# Heritage Impact Assessment

Flat 3, 40 Montagu  
Square, London

March 2021 | Project Ref 6604

2 Third Floor Plan

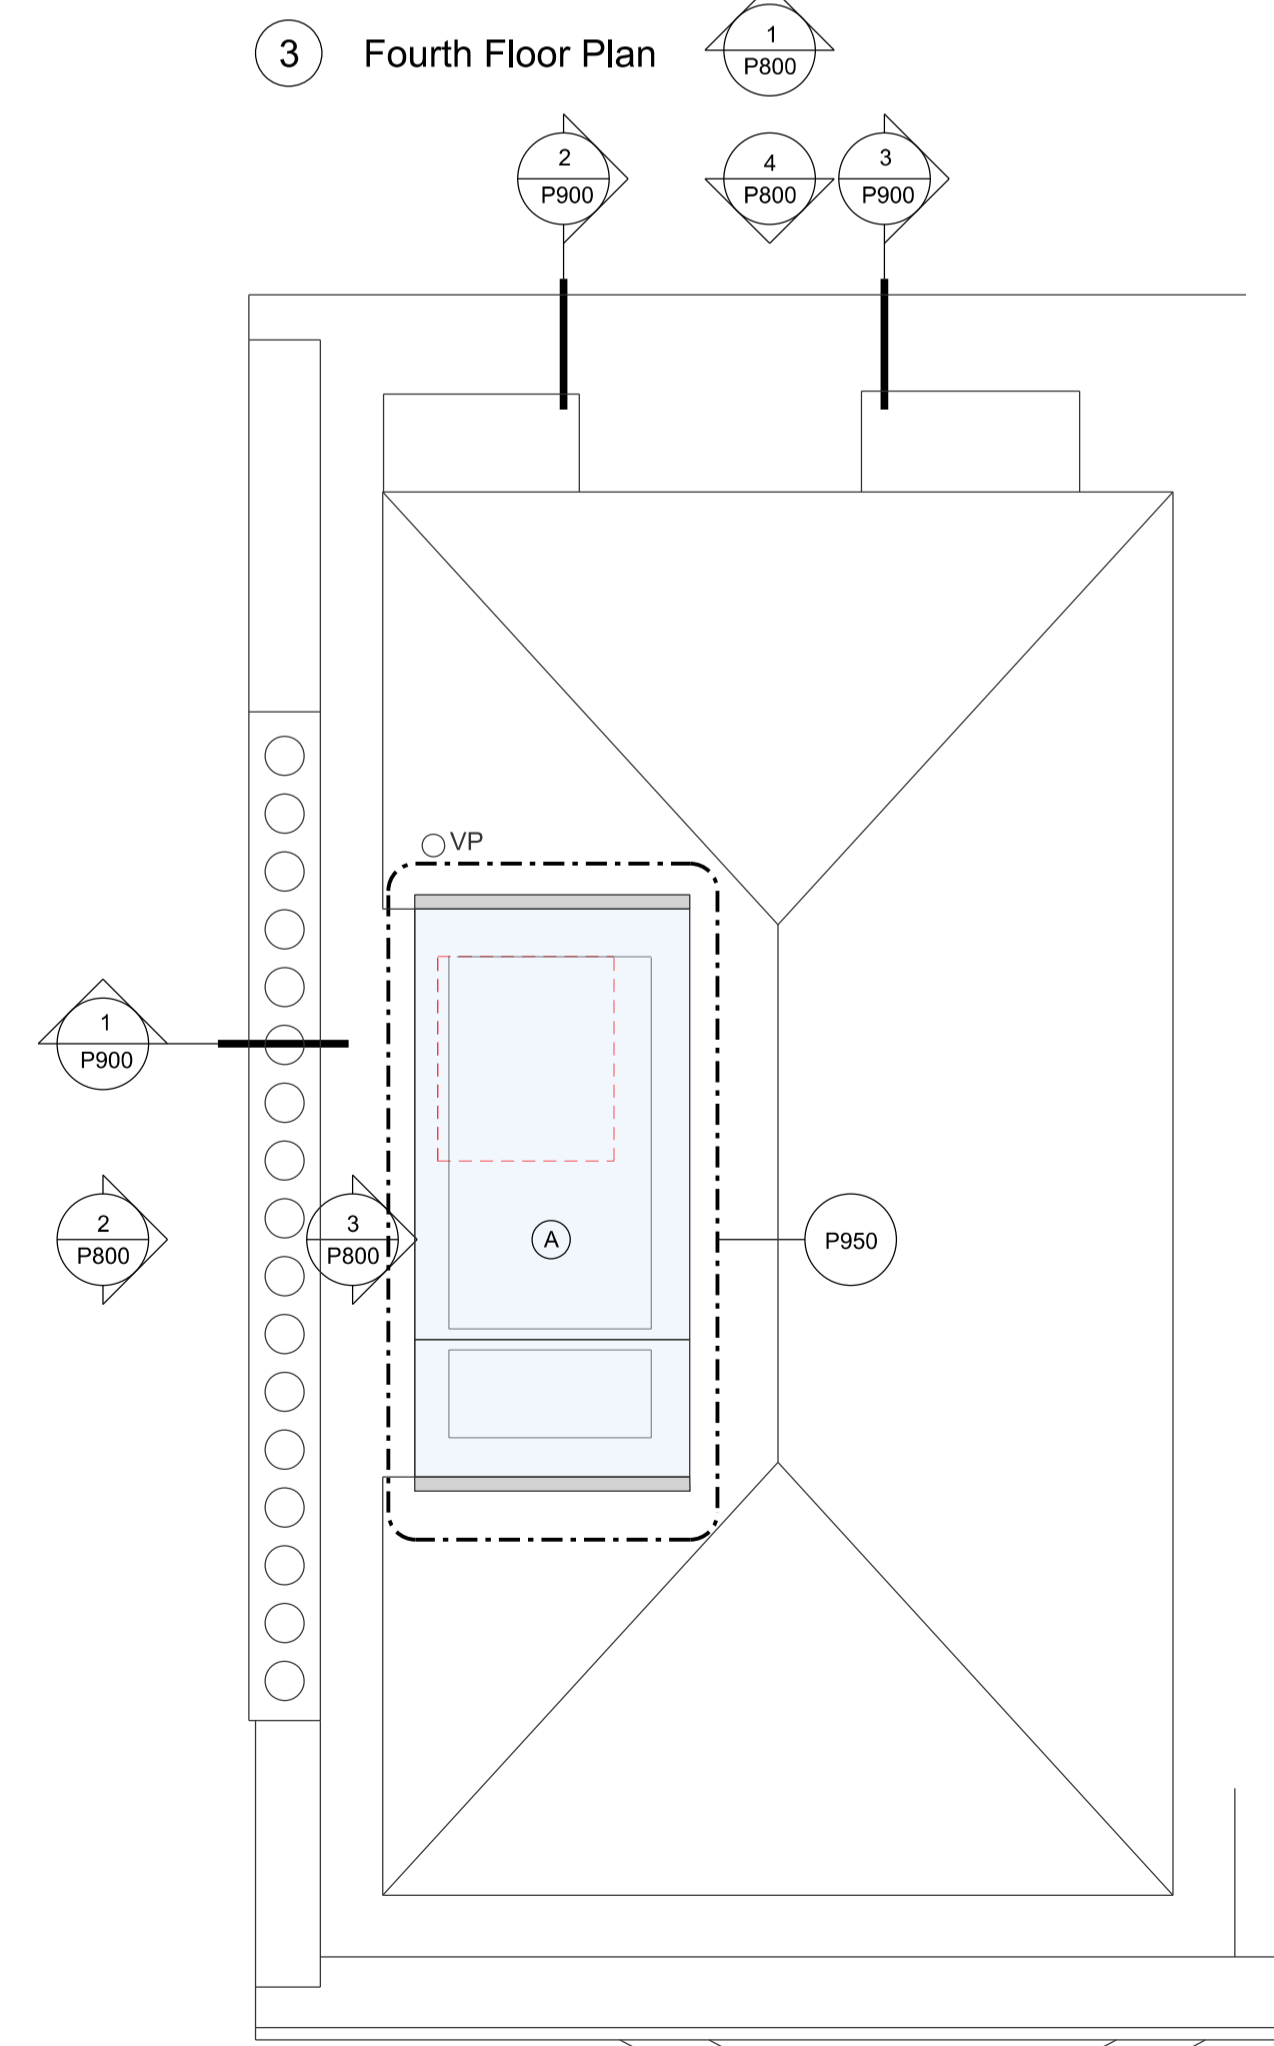
*The opening up of the third floor to form a single open plan space is unacceptable in terms of the impact on the historic plan form.*

*The loss of historic chimney breasts is also contentious, and not ordinarily consented.*

- 4.10** Two new openings will be formed in the internal partitions at third floor level. One will open the partition between the front and back rooms, currently a living room and kitchen respectively. Another will open up the partition between the front living room and the smaller, narrower room at the front. In both cases it has been decided to leave nibs and downstands so that the existing (probably mid-19<sup>th</sup> century) layout can still be “read” at all times. Cornices and existing timber beams in the ceiling will be retained. Furthermore, retractable timber shutters will be provided where the two partitions are to be opened up. This will allow the appreciation of either (1) a contemporary open-plan arrangement when the shutters are opened, or (2) a more traditional three-room arrangement when the shutters are closed.

- 4.11** Glazed doors will be provided between the landing and the two main rooms<sup>7</sup> at third floor level, so as to bring natural light down from the lantern into the central part of the house. This will replicate the existing plan as closely as possible, while significantly improving the amenity of the flat.

4 Roof Lantern and Loft Space Plan

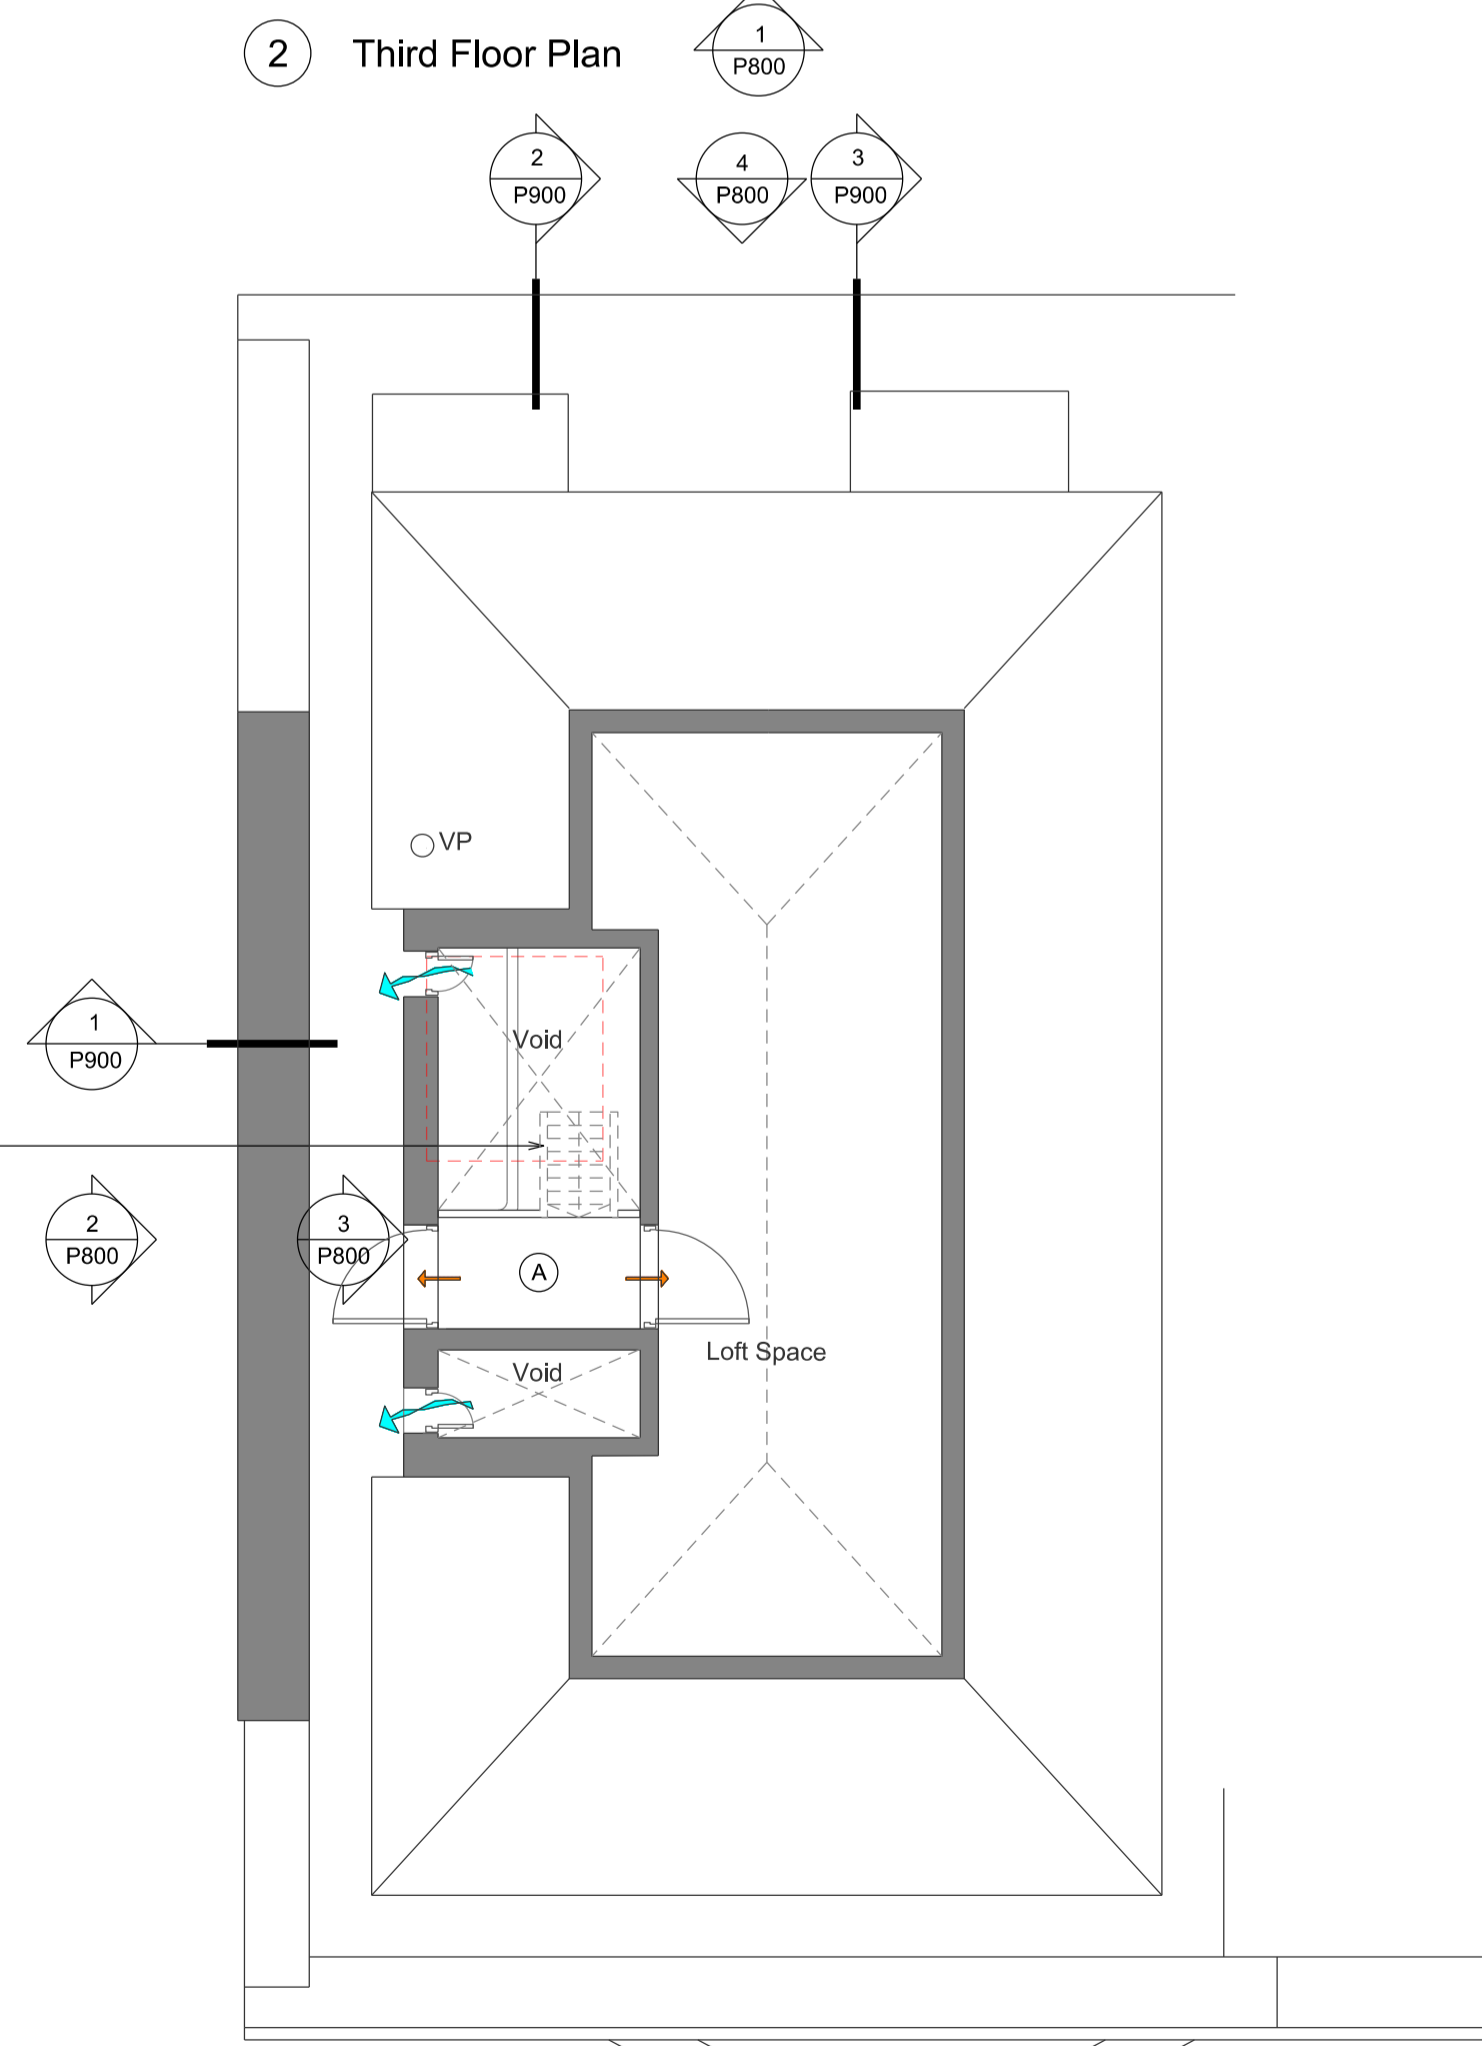
*In terms of the proposed works to the roof lantern, the date of the roof should be established before we can consent to the loss of fabric, including roof timbers. The hipped roof appears to be historic – the same roof form is repeated on almost all of the Montagu Square buildings which have the same two-storey bay as no. 40. If the roof is indeed original then the loss of roof*

*timbers to allow for an enlarged roof lantern would not be acceptable. The fabric of the lanterns itself does not appear to be of special interest - there would be no objection to the replacement of the existing lantern with one of the same volume.*

- 4.5** The principal change at roof level is the removal of the existing lantern, which appears to date to the early 20<sup>th</sup> century, perhaps around 1920 (Figures 3 to 5). It is made of timber, with wired glass on the pyramidal roof, and reeded glass on the cheeks and the casements. The interior is boarded, and it has cut through an earlier hipped roof which, from the appearance of the joists and boarding is itself likely to be a late 19<sup>th</sup> century or early 20<sup>th</sup> century alteration (Figure 6). There is nothing of special interest in the fabric of the existing rooflight, and its removal will not harm the significance of the listed building.

- 4.6** A new and enlarged rooflight is proposed. This will cut out more of the hipped roof, but the fabric of that structure is very unlikely to be original. The new rooflight will not be visible from ground level. In design terms it should be compared favourably with the lantern at 39 Montagu Square that was approved in 2008 (08/07584/LBC) (Figure 8). Other broadly similar lanterns have been approved, including 2 Montagu Square (14/0557 and 16/03489). When observed from roof level, the whole area abounds with incremental alterations and changes, most of which are hidden from public view and have no effect on the special interest of the townscape – including the structure on the roof of the neighbouring listed building, 41 Montagu Square (Figure 7).
